RE: Response to Request for Information – 3-5 Help St Chatswood

The purpose of this letter is to address the waste items in the Request For Information for the state significant development application for the proposed development at 3-5 Help St Chatswood.

Figure 59: Swept Path Diagrams – Council's Waste Vehicle

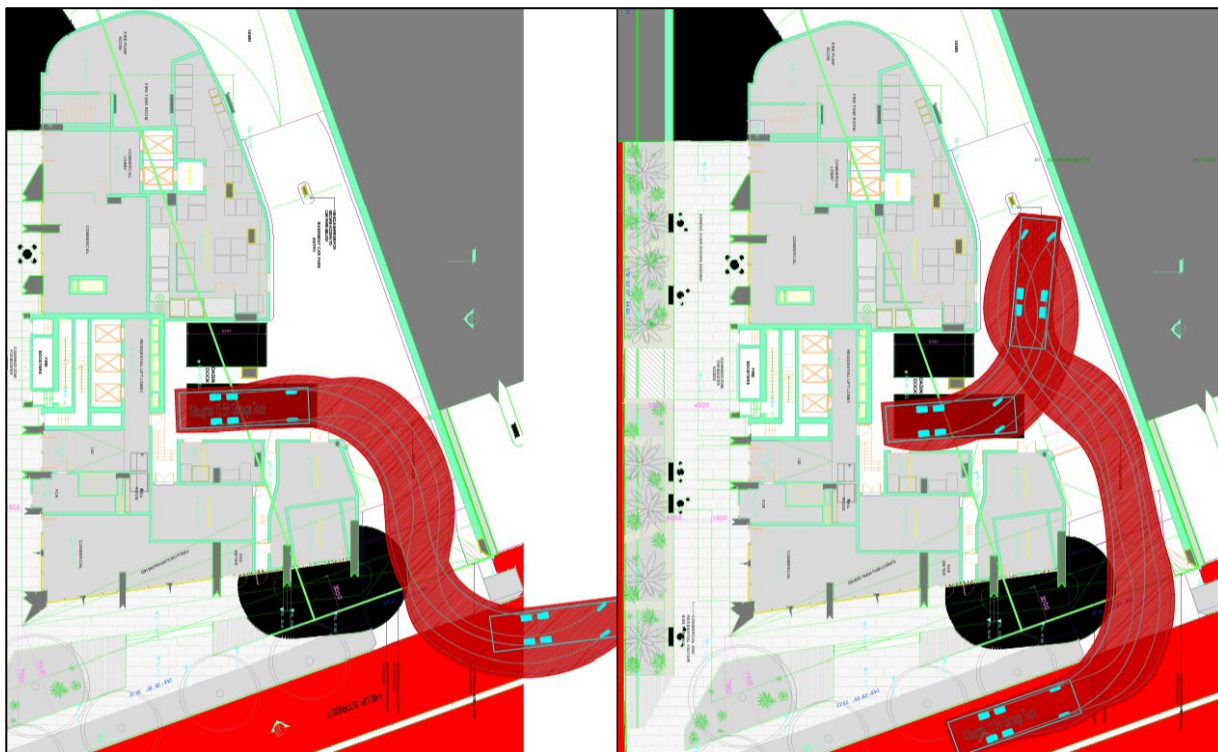
RFI Item raised by Willoughby City Council	Response
WCC-7.1 <i>The attached submission includes comments requesting amendments to ensure waste management meets the requirements of the Waste Management Technical Guide and Development Controls by Northern Sydney Regional Organisation of Councils (NSROC). Conditions are provided at Attachment 2.</i>	It is recommended that the waste management strategy is also assessed under the NSW EPA's <i>Better Practice Guide For Resource Recovery 2019</i>, where the guideline for this document results in better outcomes. It is noted that this document is at the state level and is a more recent publication.
WCC7.2 Collection of residential waste: bins and bulky waste <i>Council services residential waste, including bins and bulky waste using HRV trucks. The approved DA (2023/160), has conditions requiring swept paths to demonstrate that Council's 10.5m long HRV will fit into the site and requiring a 12.5m parking space (10.5m truck and 2m rear clearance). The same requirements and conditions need to apply to the SSDA.</i> <i>While swept paths were supplied (PDC Consultant, Transport Impact Assessment, Lower GF 1 Plan Rev 02, 17.02.2025), onsite collection with a Heavy Rigid Vehicle (HRV) was not clearly stated contrary to the Willoughby DCP 2023 Vehicular Access Requirements (NSROC 2018, p34, Table 11).</i> <i>There are two loading bays shown, an SRV bay and an MRV bay and no bays labelled HRV.</i> <i>There are discrepancies between plans in the length of the truck: o Public domain</i>	- The space designated for the Council Waste Truck has been noted as a HRV bay on the updated Drawing SSDA-1010, Revision D dated August 2025 prepared by Embece - Drawing SSDA-1010, Revision D dated August 2025 prepared by Embece and Public Domain Plan both now show a 10.5m truck - A 2m clearance has been labelled on the architectural plans for the HRV space. Council waste truck will reverse into the loading dock area on arrival and drive straight out on to Help Street on departure. It is anticipated that the SRV parking space would only be used on rare occasions be occupied and therefore the bin carting route could pass through the SRV space in most instances. If the SRV space is occupied, the bins will be wheeled towards the bulky waste area and follow the route towards the rear loading area. The bin moving route is depicted below.

plan (EMBECE, Issue - 20.12.2024) shows an 8.8m truck. o LG plan (EMBECE, Issue C, 08.05.2025) shows a 10.5m truck.

- The MRV bay does not show a labelled 2m rear clearance.
- All bin rooms are not located with 2m of the truck parking space and the access to the residential waste holding room is limited due to the SRV bay location if the Council HRV stopped in the existing MRV bay.

In addition, it is not clearly shown how bins and bulky waste will be wheeled or carried around the truck with a 2m clearance for walkway (NSROC 2018, Section 3.16.2 Bin Carting Routes for caretakers and waste Collection Providers. The loading area needs to be designed so that Council's HRV (10.5m long) has a 12.5m long parking space within 2m of each residential collection holding room (bins and bulky waste).

It is noted that the NSW EPA's *Better Practice Guide For Resource Recovery in Residential Developments 2019 – Appendix B Collection services and vehicles* recommends that the route from the bin storage area to the collection point be within 10m of the layback from the nominated collection point.

It is recommended that this requirement is applied to the site rather than the NSROC 2018 guideline, as locating all bin rooms within 2m of the collection vehicle is not realistic in most developments.
